From: Harry Chalk <Harry.Chalk@arun.gov.uk>
Sent: 30 May 2022 13:18
To: Brian Elstone [REDACTED]
Cc: Juan Baeza <Juan.Baeza@arun.gov.uk>; Anita Gardner <Anita.Gardner@arun.gov.uk>
Subject: LU/93/22/PL - Description Clarification.
Importance: High

I've been going through the submitted documents and have noticed that the description may not accurately reflect the proposal. I note that the description currently reads 'Replacement of 43 No. existing timber windows with new double glazed PVCu windows. This application is in CIL Zone (Zero Rated) as other development.'

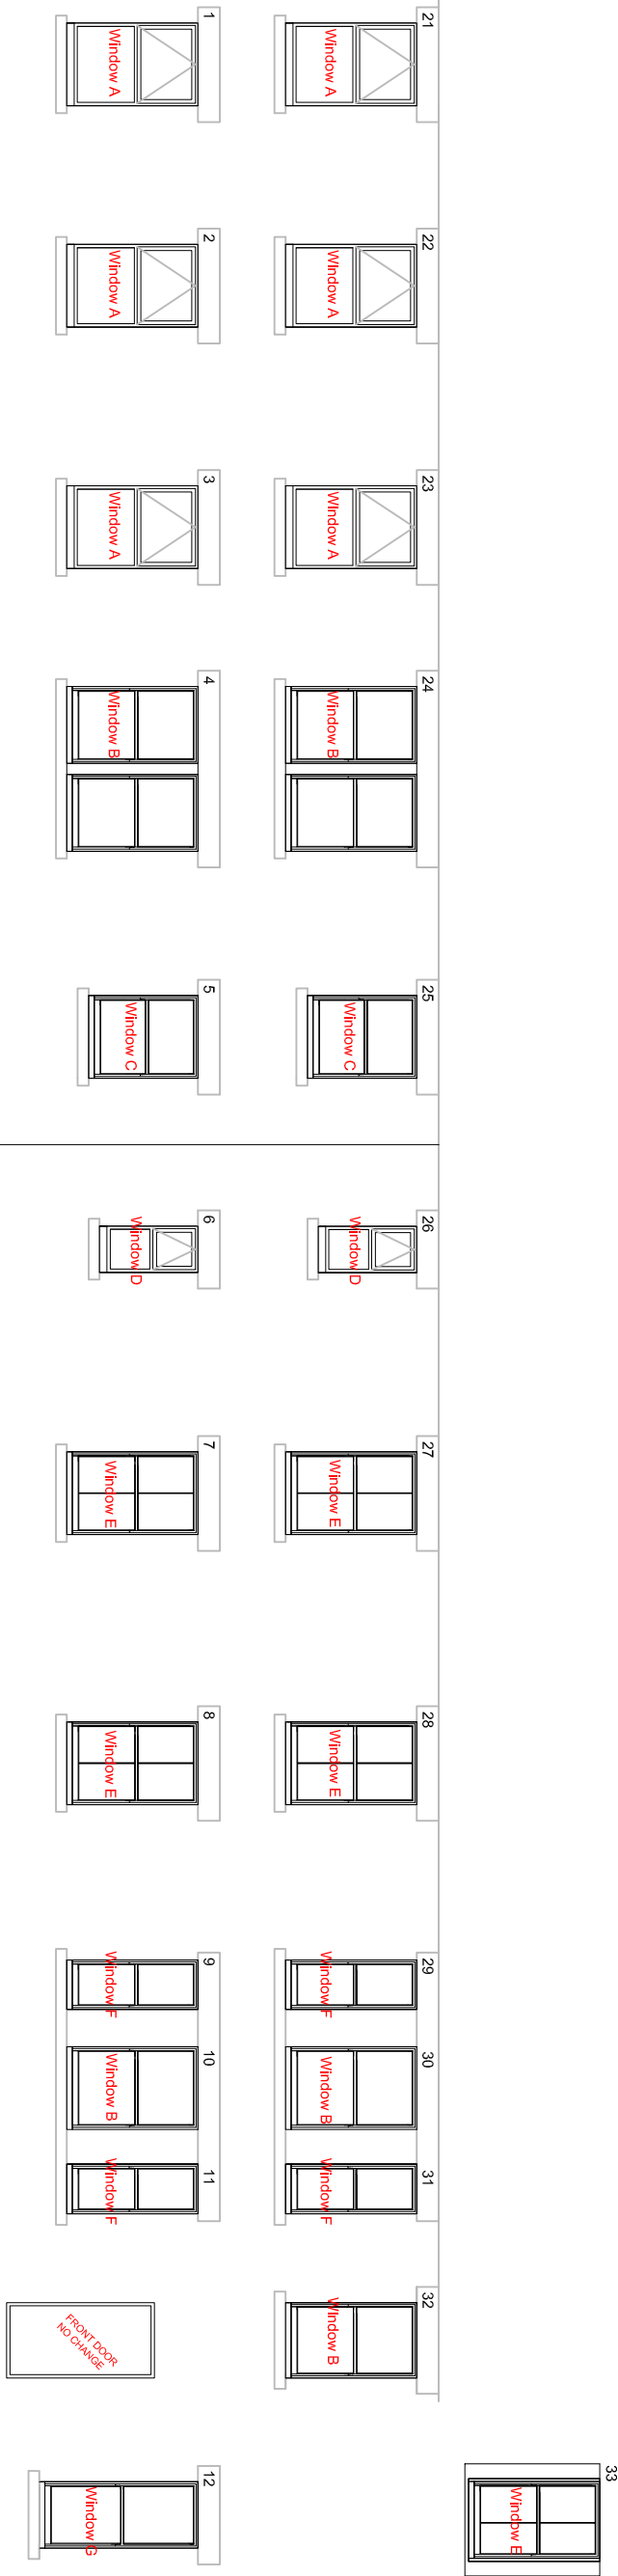
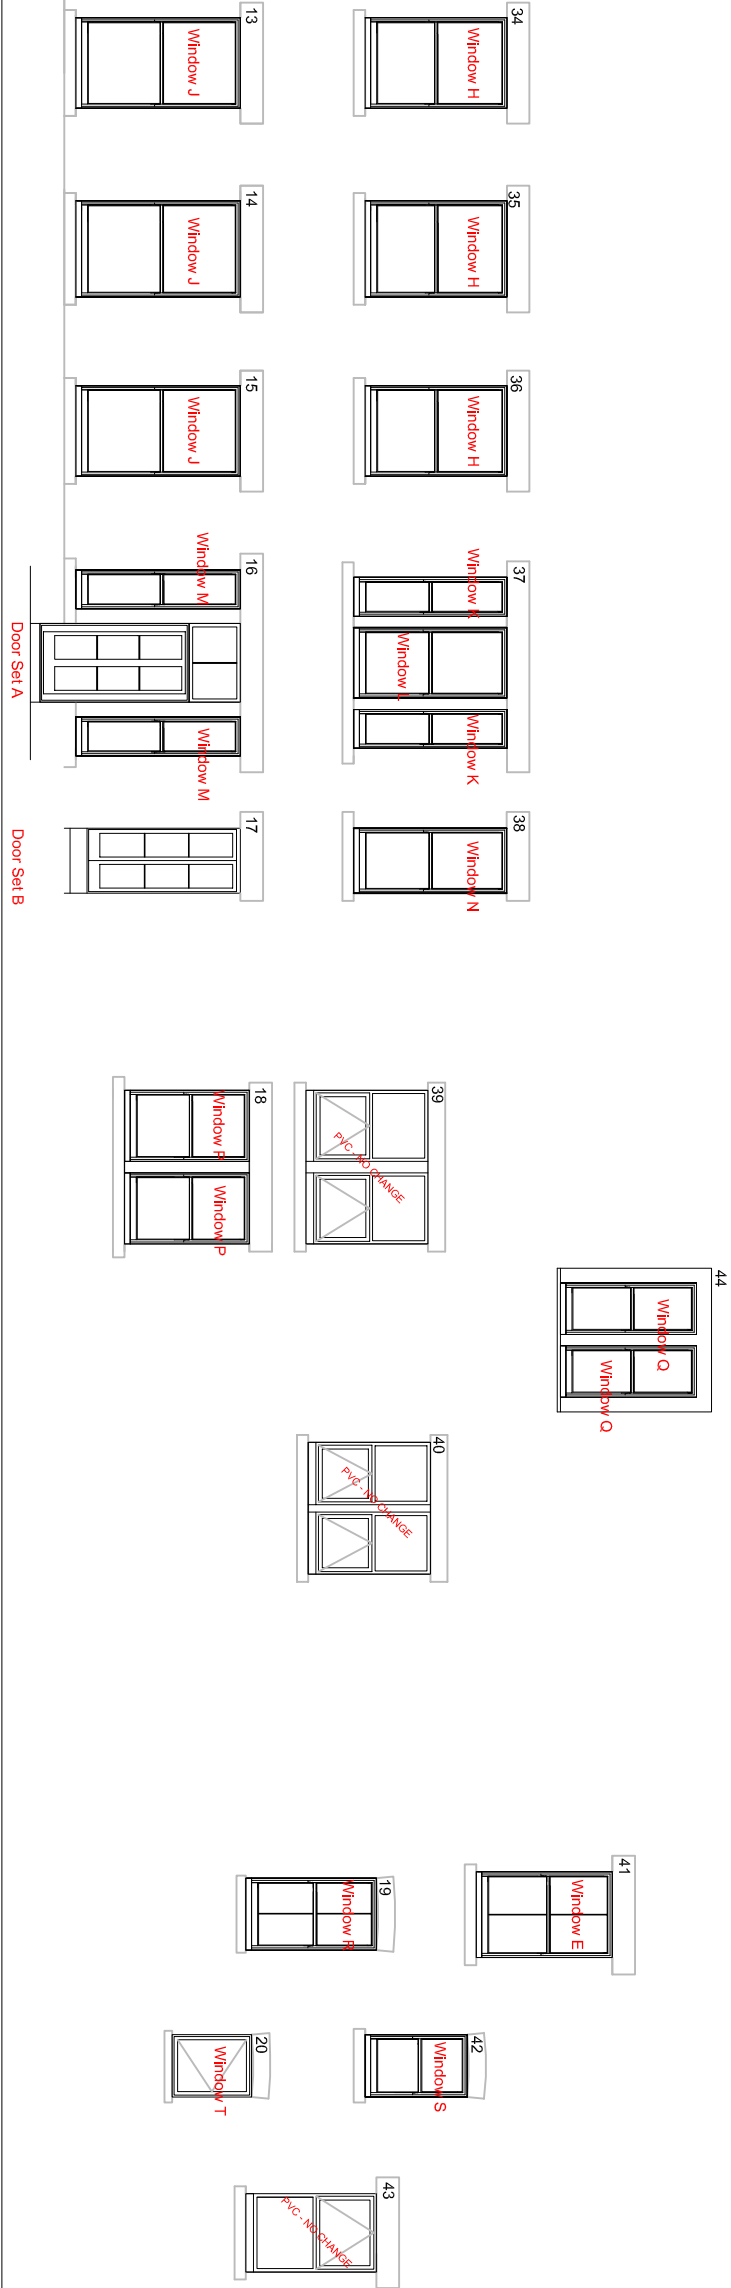
The elevational sheet appears to show that 3 of the total 43 No. windows are labelled as 'PVC – No Change' and the application form description only regards replacement of existing timber frame windows.

Could you confirm if the description would better read as 'Replacement of 40 No. existing timber windows with new double glazed PVCu windows. This application is in CIL Zone (Zero Rated) as other development.'?

Yes you are correct in this. Only 40 windows to be replaced. Sorry for any confusion, although those already replaced may not have had permission.
